Town & Country Planning Act 1990 (as amended)
Town and Country Planning (Development Management Procedure) (England) Order 2015

Application for Planning Permission

Development: Installation of 3 No. flues. This application is in CIL Zone 4 (Zero Rated) as 'other development'.
Location: Block B, Unit Q Arndale Road Littlehampton BN17 7GA

Proposed Elevations

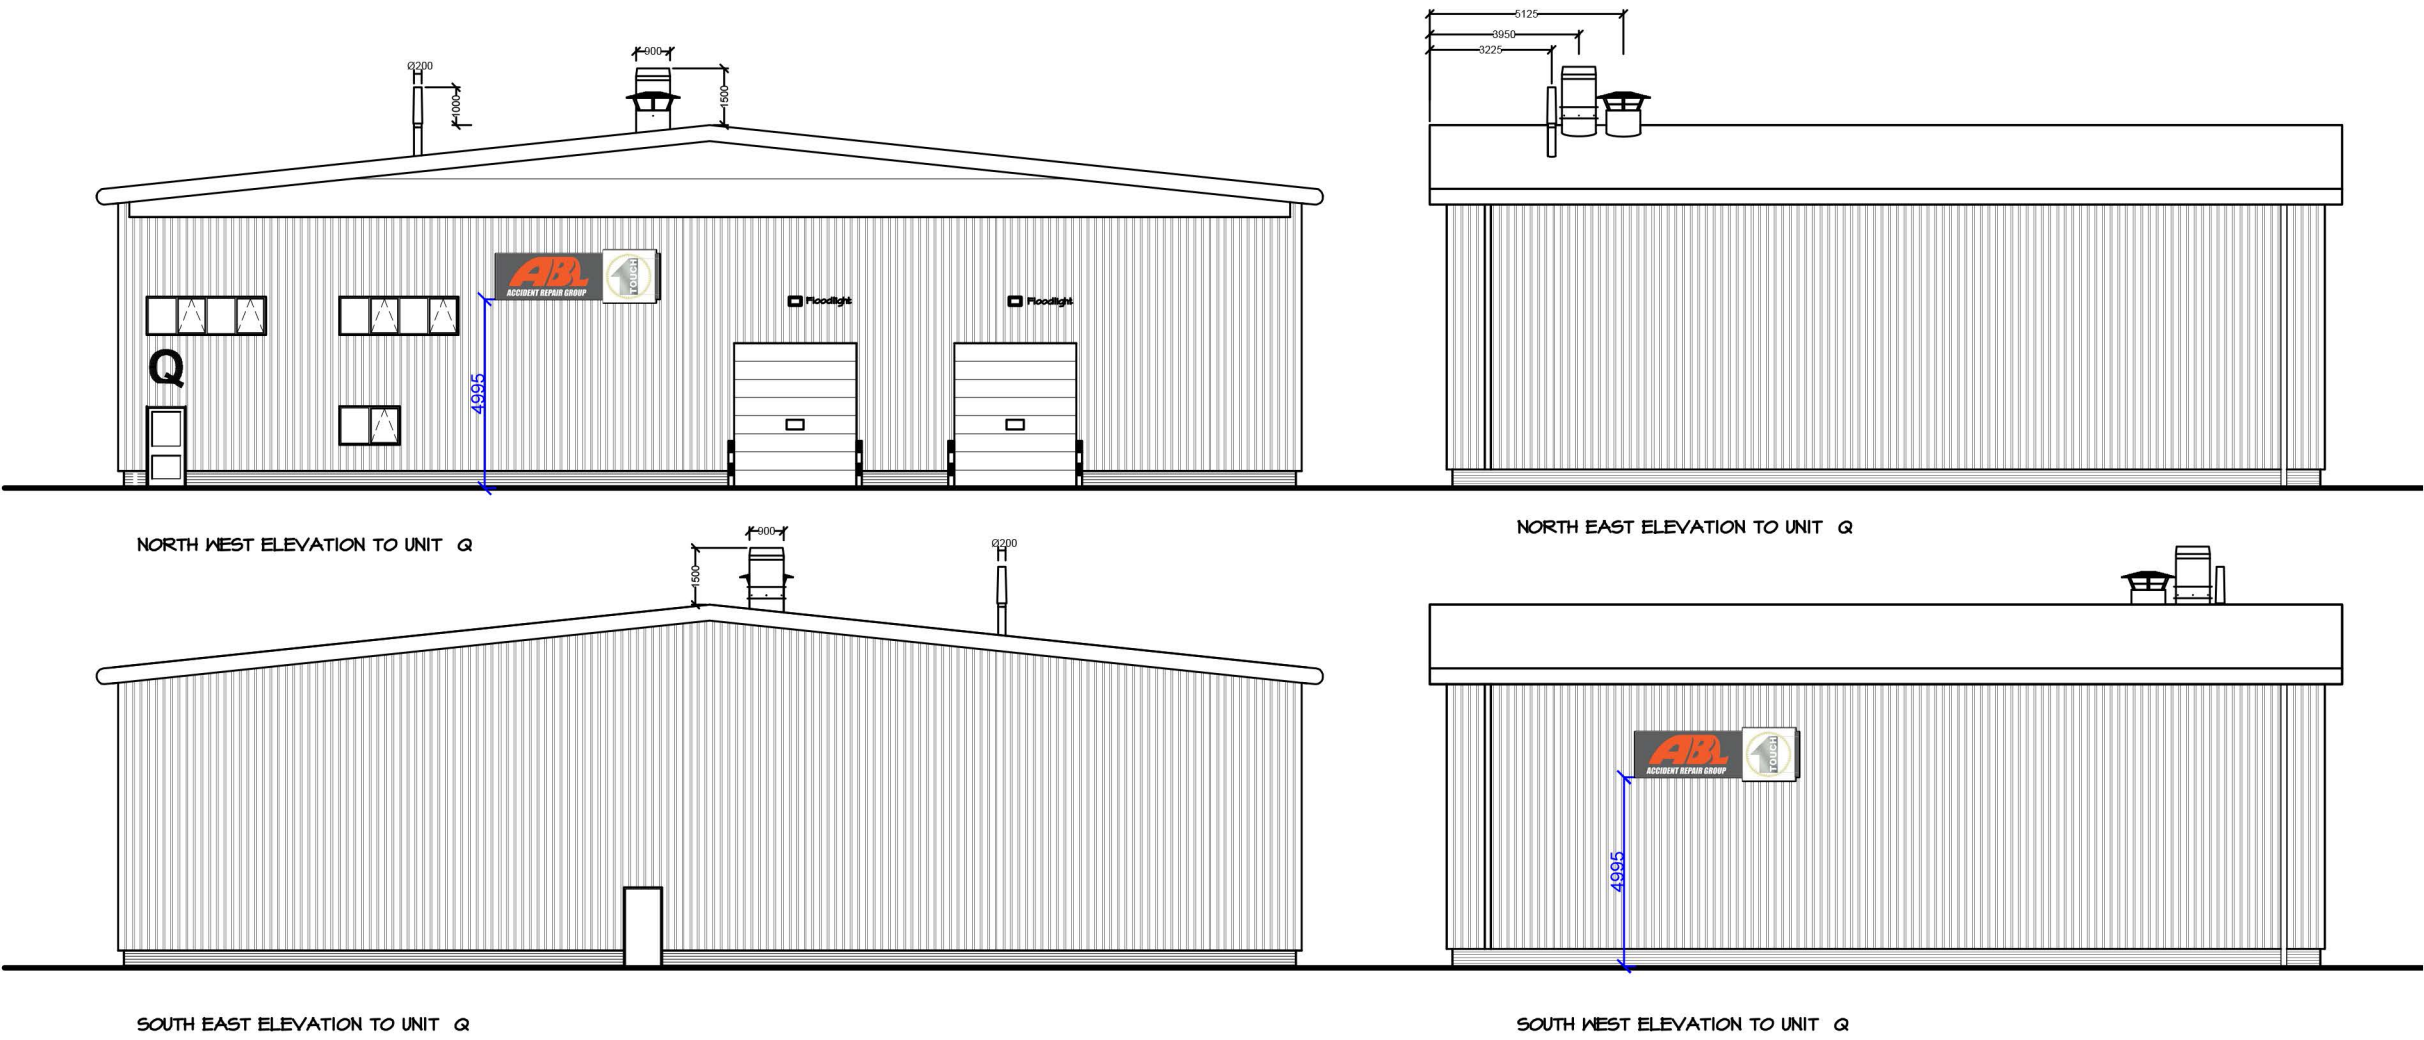
It is not clear if the 3 No flues will be standing up outside of the existing roof. Please confirm if the flues will be seen from the roof. If the flues will be seen on the outside, please provide a proposed roof plan showing the position of the flues and elevations to show the flues.
